# DUNGOG SHIRE COUNCIL

**RE: MARTINS CREEK QUARRY PROJECT SSD-6612**

**SUBMISSION TO AMENDED STATE SIGNIFICANT**

**DEVELOPMENT 6612 – MARTINS CREEK QUARRY PROJECT**

FIGURE 6.39  
Final Landform  
Cross Sections

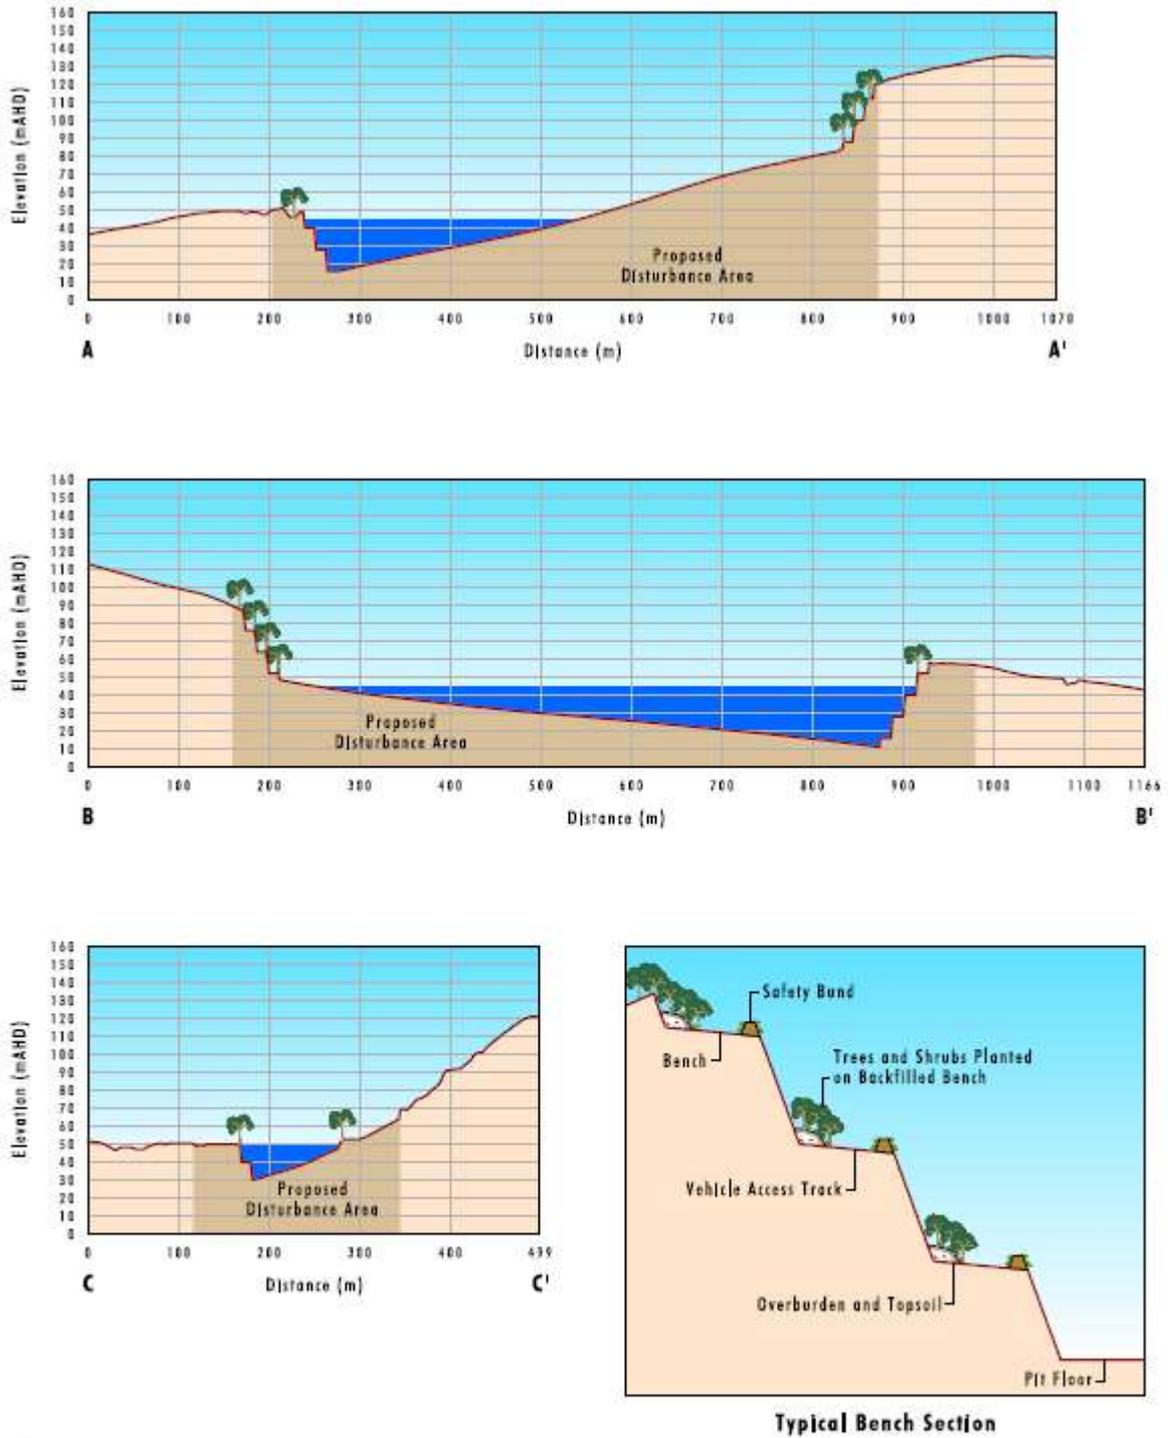
Section 6.17 of the amended report addresses visual amenity, while Section 6.19 addresses the rehabilitation and final landform. Both of these utilise a series of cross sections in an attempt to illustrate the visual impact of the quarry during operations and following rehabilitation. The cross sections provided are ineffective and do not provide a clear representation of the visual impact of the proposal. A series of photomontages should be provided to assist in assessing the visual impact of the proposal and the proposed final landform.
